Project: 115201-5.3.1.5

**RE: RESPONSE TO COMMENTS LETTER  
380 ROLLING MEADOW CRESCENT – SUBMISSION #1**

With reference to the above mentioned submission and your comments in your Memorandum dated December 24, 2018, please see our responses below:

Checked _____

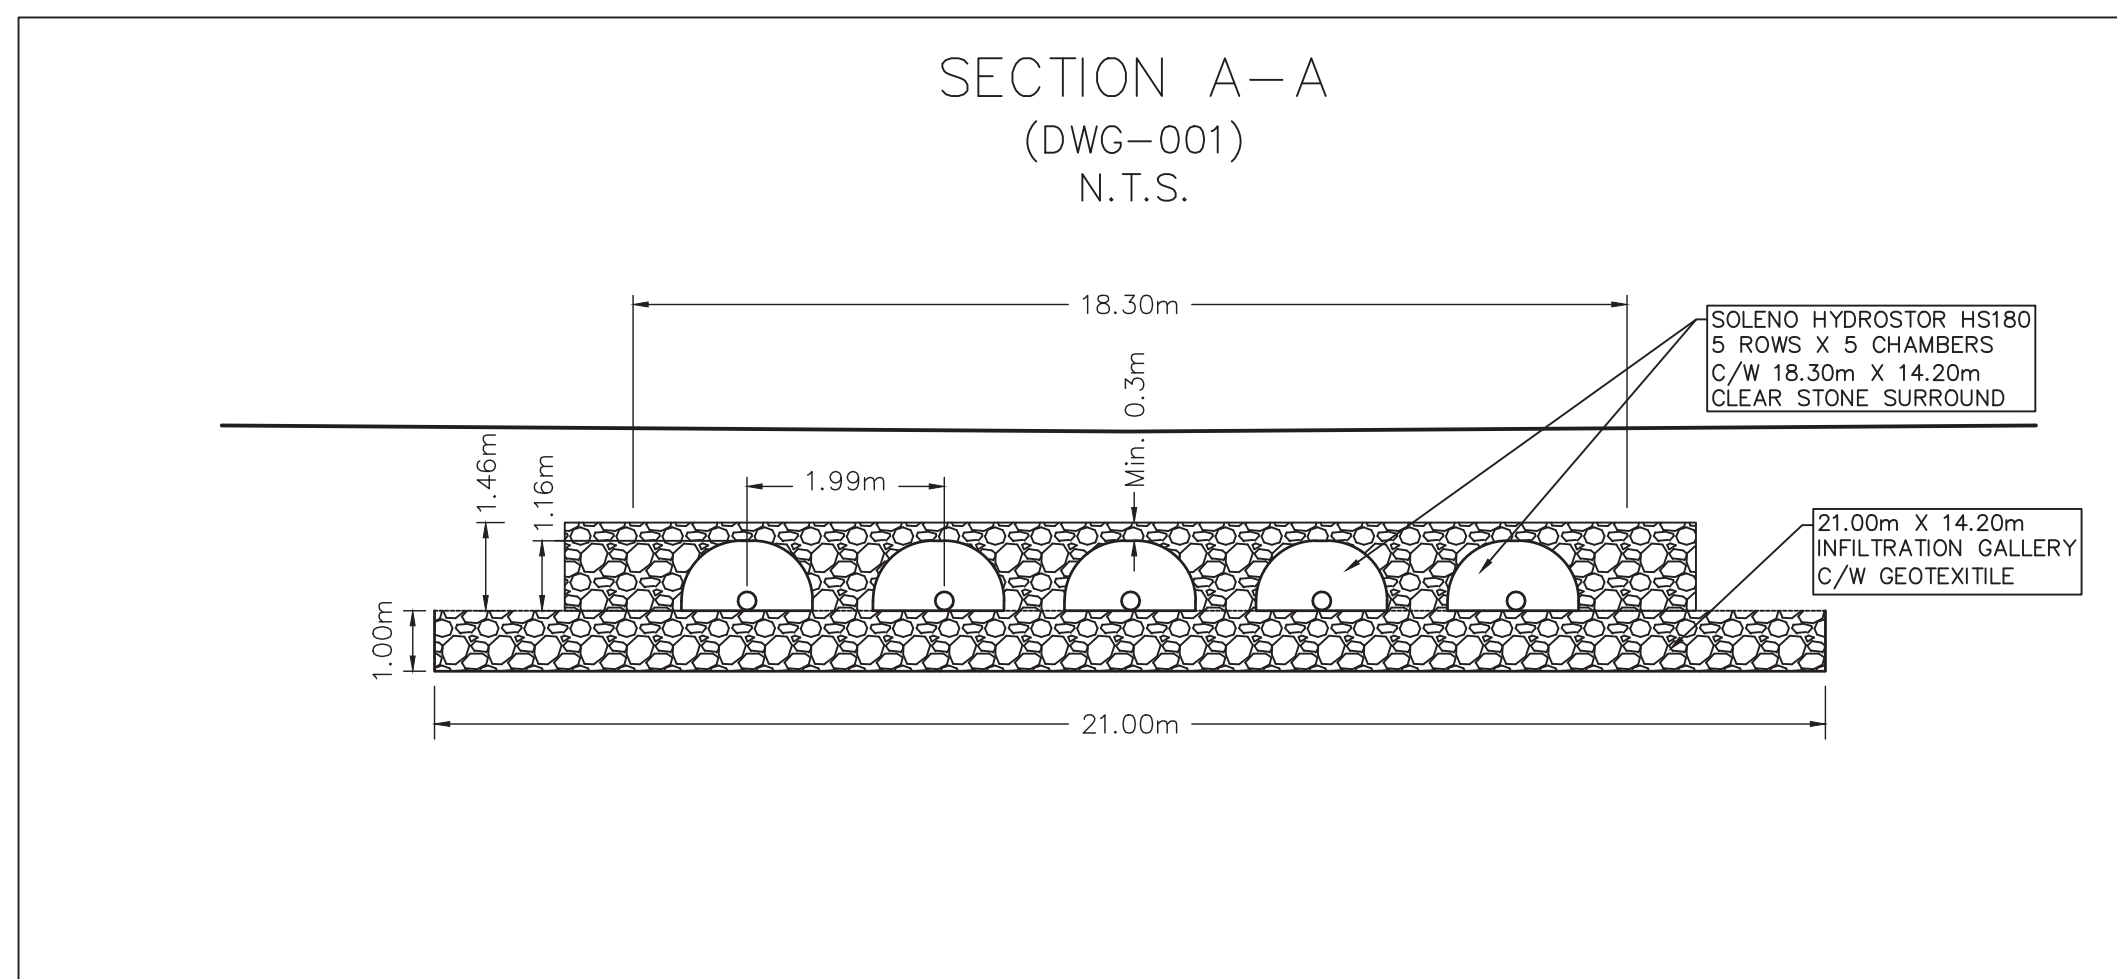
42. Ensure that all symbols listed in the Legend are referenced to the appropriate standards, as required. Likewise, ensure that all symbols shown on the drawings are listed in the Legend (ex.: floor drain on Grading Plan not shown on the Legend).

43. The CB Data Table is listed on Drawing No. 001 – General Plan of Servicing and not on this drawing.

*Floor drain symbol added to legend.*

*CB Table removed from title block.*
